JEFF MORTENSEN & ASSOCIATES, INC. □ ENGINEERS & SURVEYORS □ (505) 345-4250
6010-B MIDWAY PARK BLVD. N.E. □ ALBUQUERQUE □ NEW MEXICO 87109 □ FAX (505) 345-4254

July 18, 1996

Re: Edith/Candelaria E.R.O. Site (G15/D42)

JOB NO. 920393
DATE 09-1993
SHEET 1 OF 2

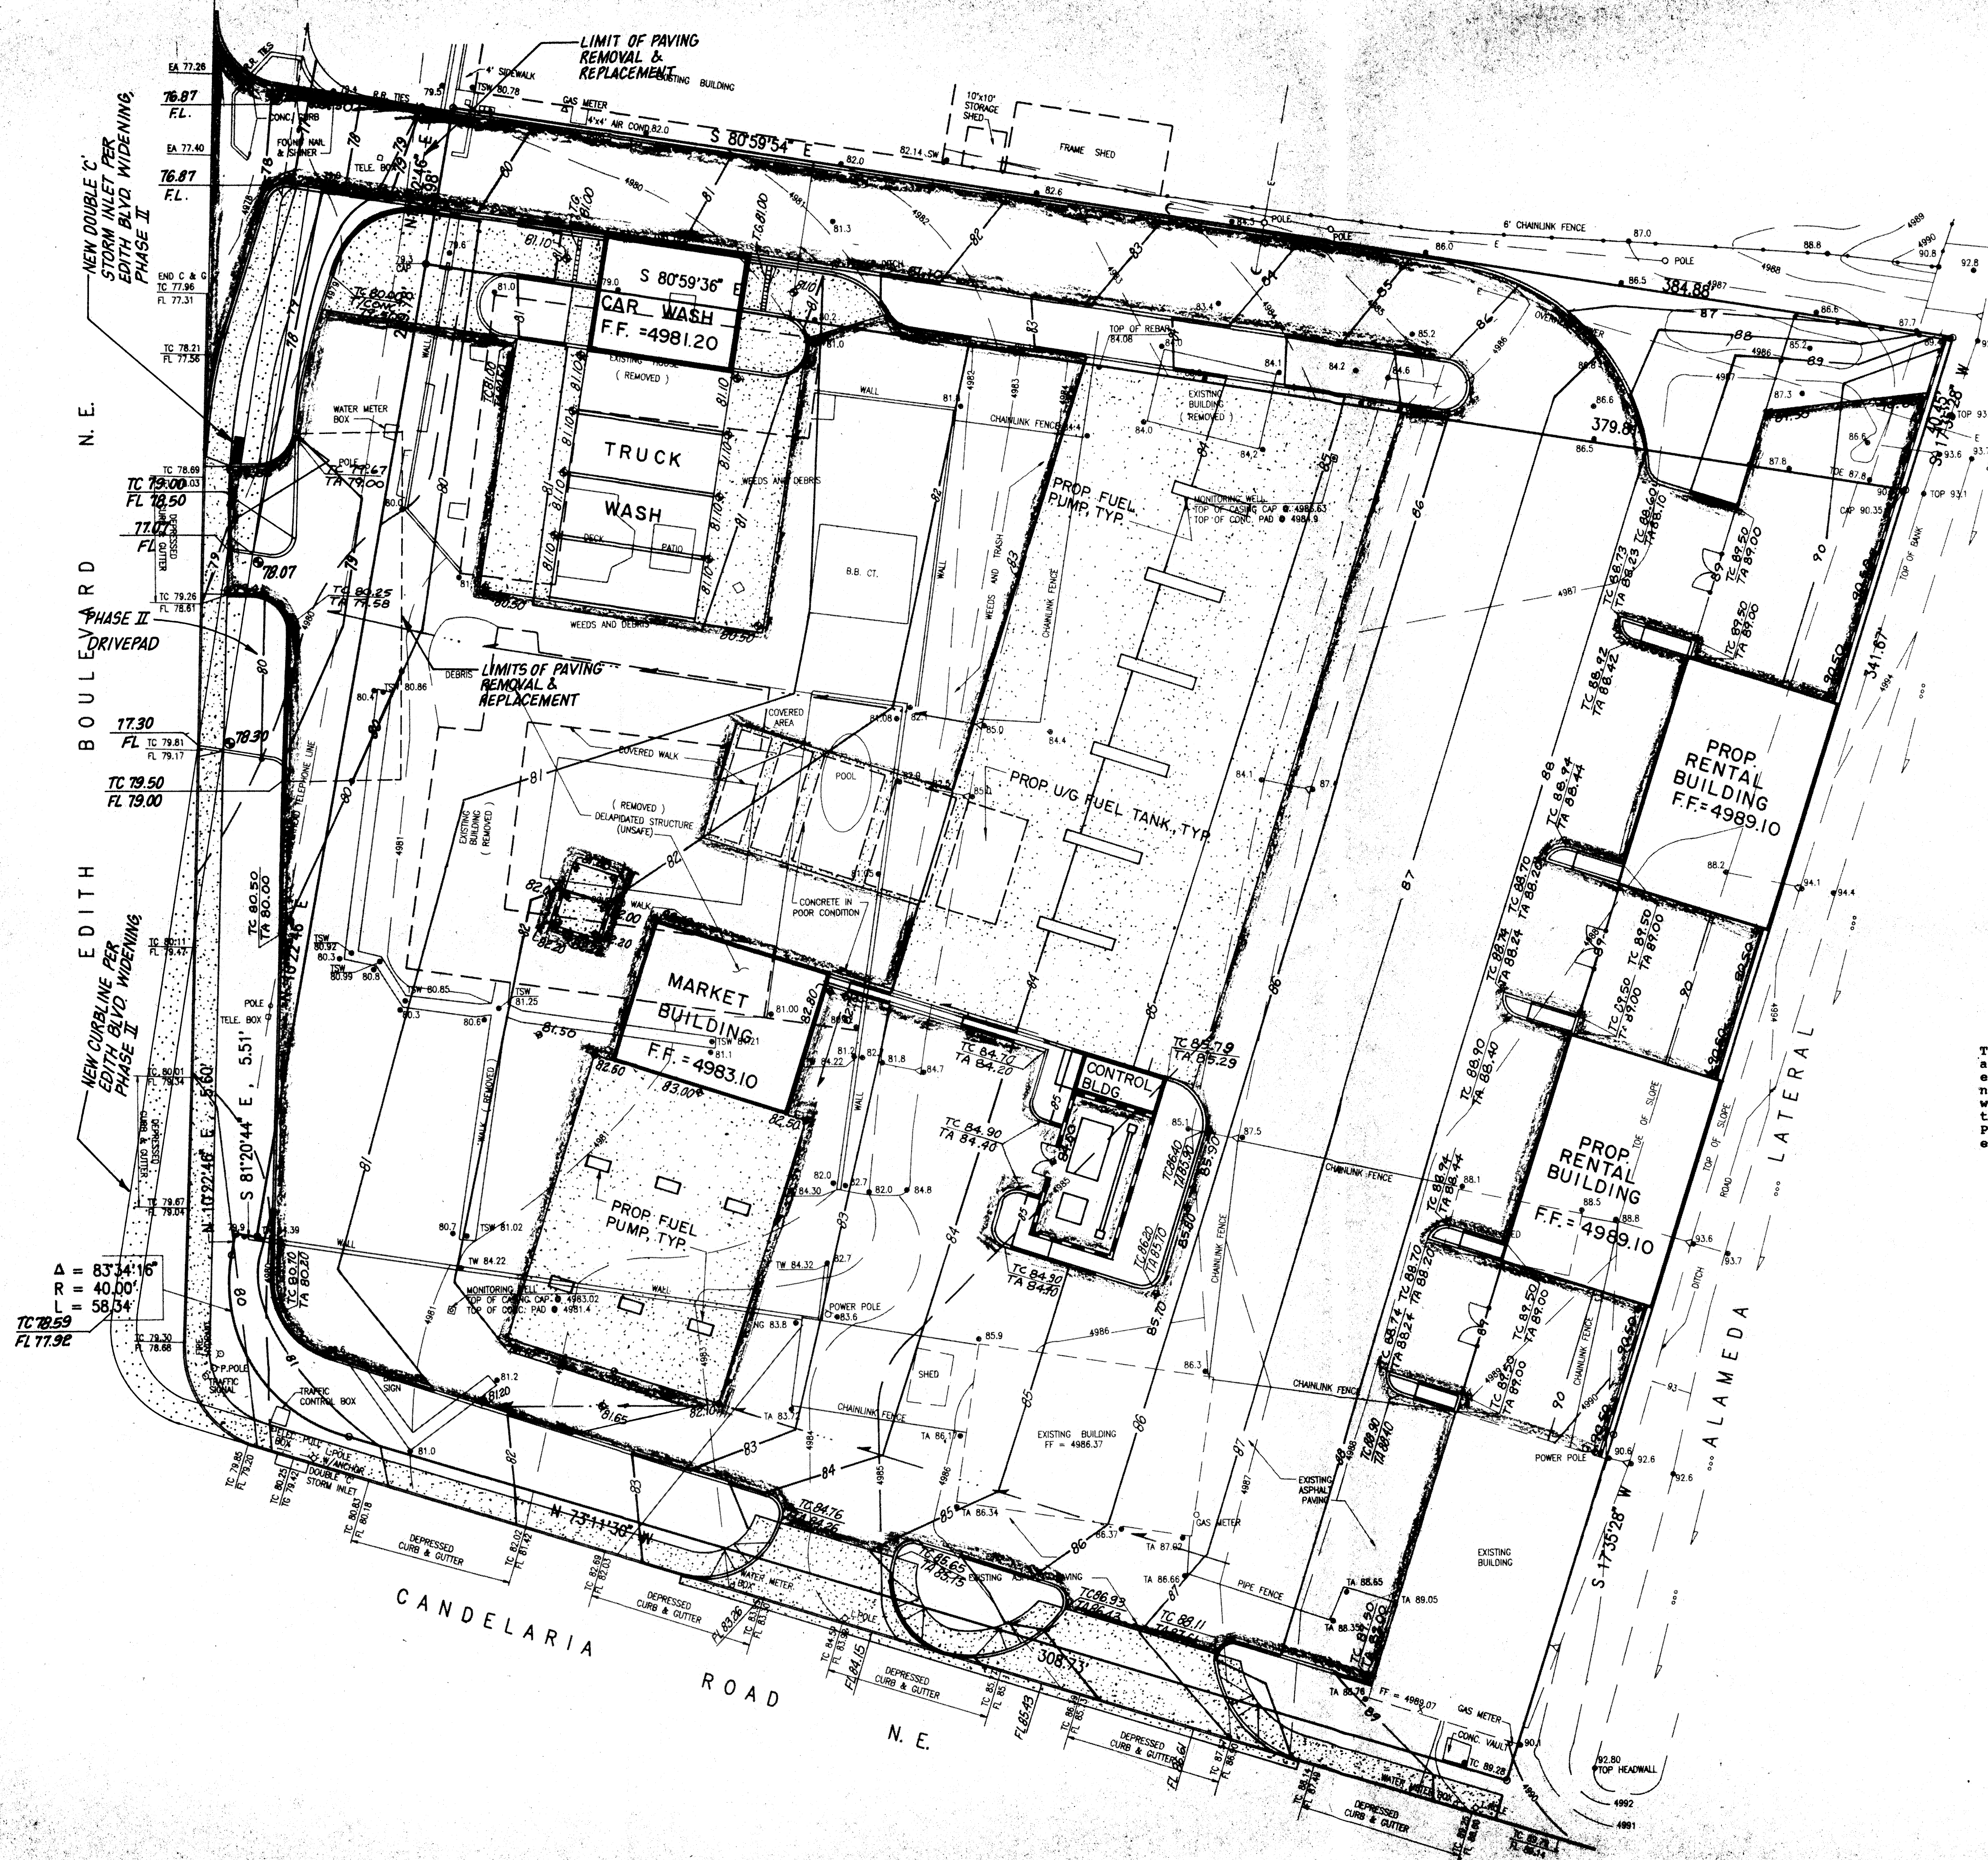
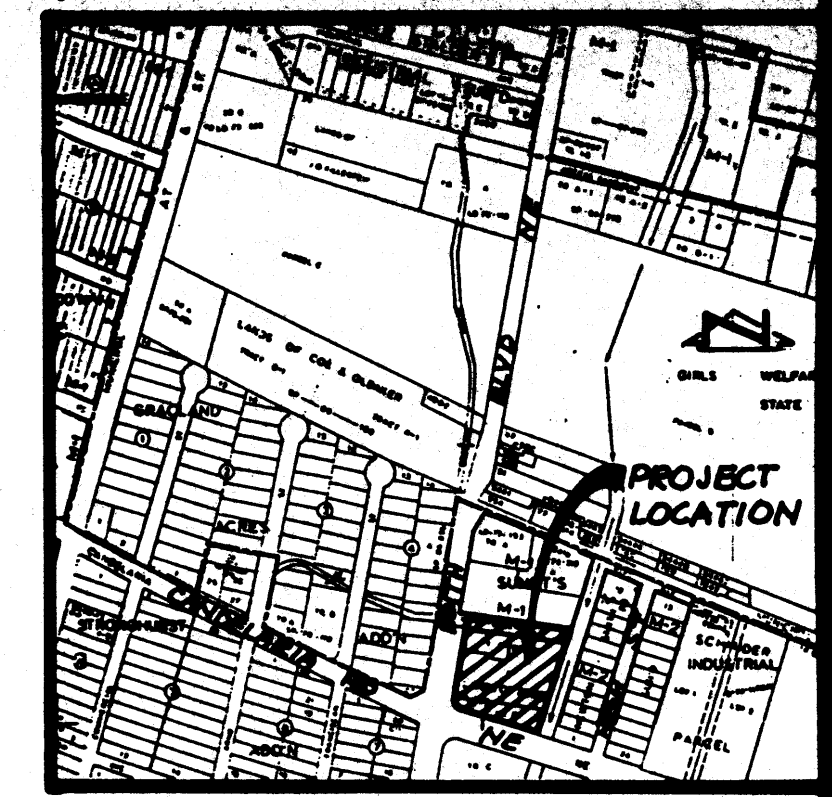
1. The private storm inlet located at the southwest corner of the site is clogged.
2. The existing retention pond which parallels Edith Boulevard N.E. no longer conforms to the approved design grades.
3. The depressed curb and gutter remaining from the pre-existing drivepad has not been closed and therefore allows overflow runoff to exit the pond.
4. Some surface runoff may be exiting the site per the northerly entrance onto Edith Boulevard N.E. Although that is consistent with the approved plan, the construction of an asphalt speed hump, to serve as a waterblock, will serve to detain more runoff onsite.

1. Unclog the existing storm inlet as soon as possible.
2. Restore the pond to its "as designed" grades (i.e., grade the pond as deep as possible so as not to exceed 3:1 side slopes.
3. Close the pre-existing curb cut onto Edith Boulevard at the southwest corner of the site at your earliest convenience. This can be done with either asphalt or concrete.

4. Consider voluntarily constructing an asphalt waterblock at the north entrance/exit onto Edith Boulevard N.E.
